DOC18/56565
MP 07_0087 MOD 4

OEH Review of Environmental Assessment: Bloomfield Colliery Life of Mine Extension – Modification 4 (MP 07_0087 MOD 4) – Cessnock City Council LGA

**Figure 4:** Proposed clearing for the widening of the haul road and upgrade of a watercourse

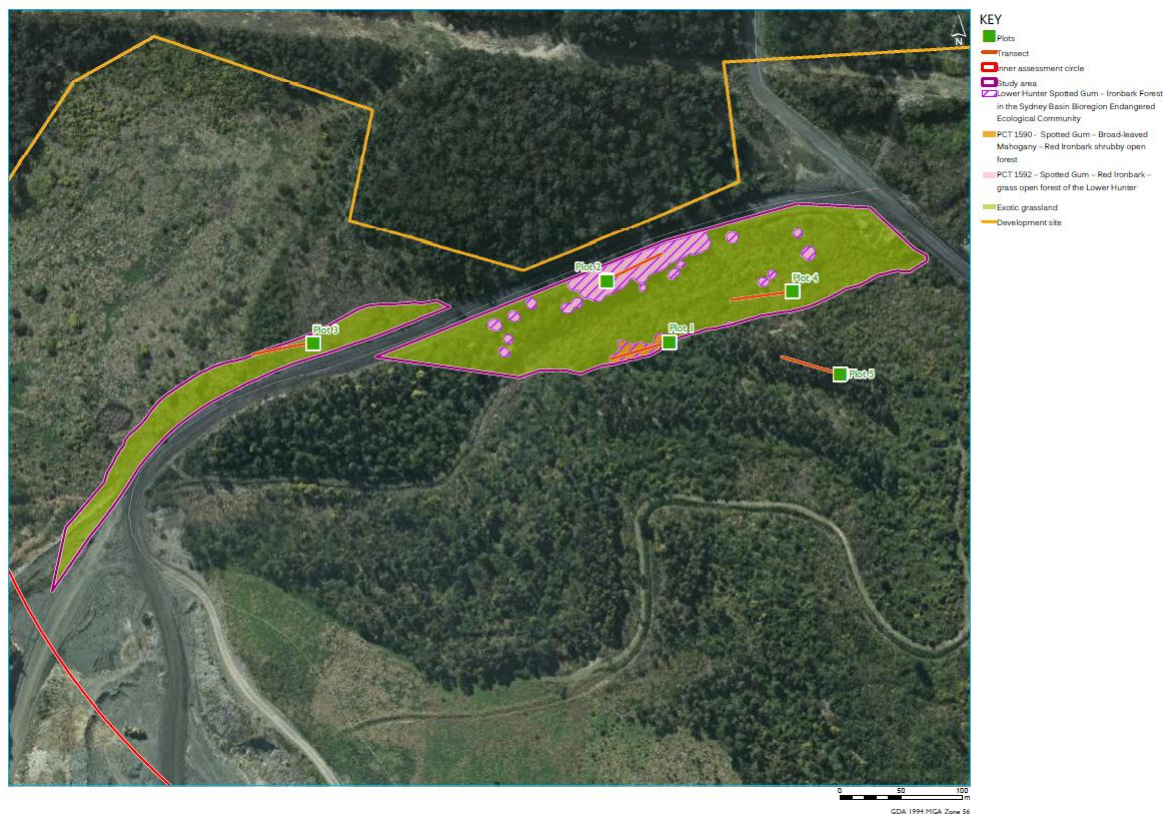
The proposal will impact on approximately 3.5 hectares of vegetation for the purposes of widening a haul road, of which 3.2 hectares is described as non-native vegetation dominated by exotic grasses (predominantly *Chloris gayana*) and scattered regenerating shrubs and eucalypts (including *Corymbia*). This vegetation has been assessed as having a site value score of less than 17 and as such requires no further assessment or offsetting under the Framework for Biodiversity Assessment (FBA).

The remaining 0.3 hectares is described as native vegetation represented by two Plant Community Types (PCT): (i) PCT 1590 *Spotted Gum – Broad-leaved Mahogany – Red Ironbark shrubby open forest* (0.05 hectares) and (ii) PCT 1592 *Spotted Gum – Red Ironbark – Grey Gum – grassy open forest of the Lower Hunter* (0.29 hectares). OEH has reviewed the Biodiversity Assessment Report with respect to the impact to the above PCTs and is satisfied with the biodiversity assessment. The proposal requires the retirement of 10 'ecosystem credits' (as per 'Credit Profile' in Appendix D).

OEH is satisfied with the biodiversity assessment provided and no further assessment is required.
